Our Case Number: ABP-317560-23

Re: Proposed windfarm development including 13 no. wind turbines in Bunnyconnellan, Co. Mayo and hydrogen plant in Castleconnor, Co. Sligo.
Carrowleagh, Bunnyconnellan, Co. Mayo and Curraun, Castleconnor, Co. Sligo.

Re: ABP -317560-2324

Figure 1.3 Hydrogen Plant Site House Locations

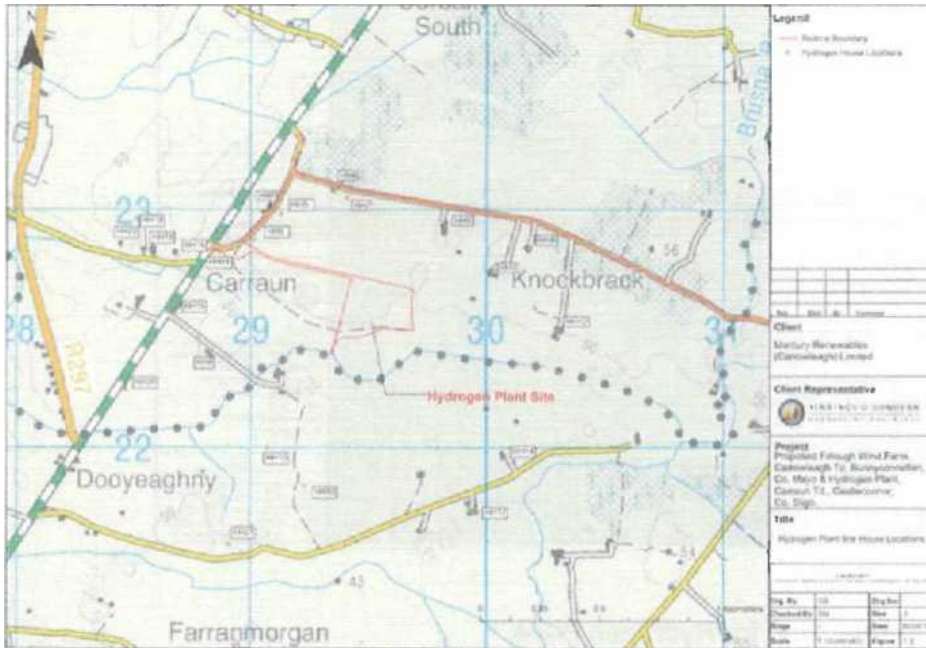
Figure 1.3 in the EIAR shows Hydrogen plant site house locations. This is referred to in the Noise and Vibration chapter 11 of the EIAR. However, due to inaccuracies re houses Hh10 and HH13 detailed in this chapter, (which don't exist) I fear that other information in this chapter may also be incorrect.

Figure 11.9 Noise Contour Map for Hydrogen Plant

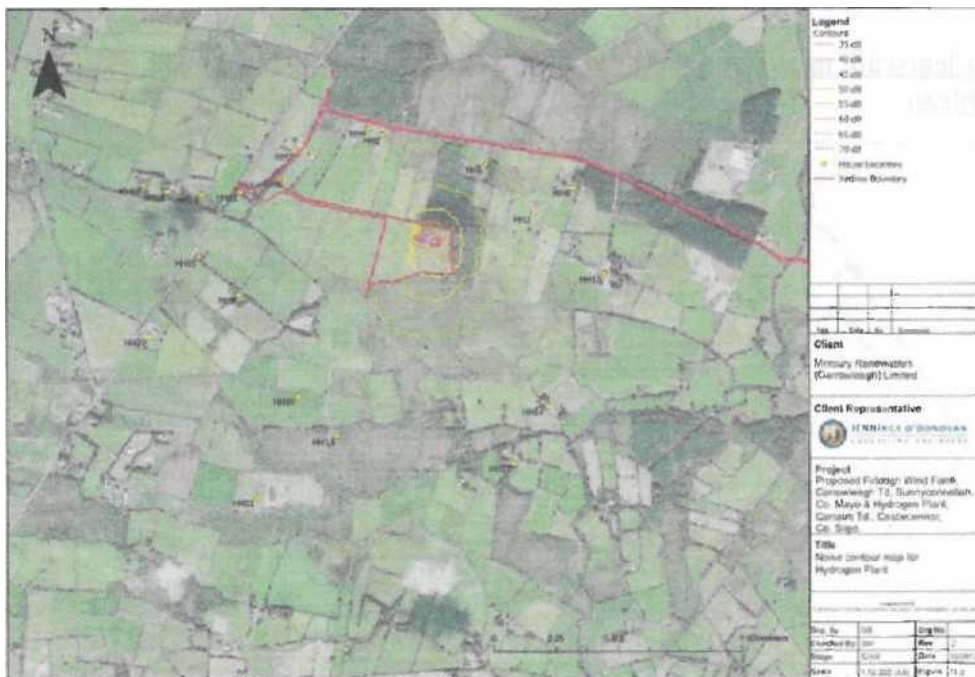
Fin-fan coolers produce 102dBA and the Applicant advises that they will have an enclosure that attenuates by 12dB, giving a total of 90dB. Yet the highest noise contour shown on Figure 11.9 is 70dBA. The figure of 102dBA is similar to

15.9 Added to the Electrolyser building noise and the Fin fans, are the Compressors (60dBA =85dBA-25dB)., Transformer (88dBA), Water Treatment Pumps (85dBA) and Other Pumps, Fans etc. (85dBA). All this adds up to a considerable noise profile which Figure 11.9 does not fairly represent.
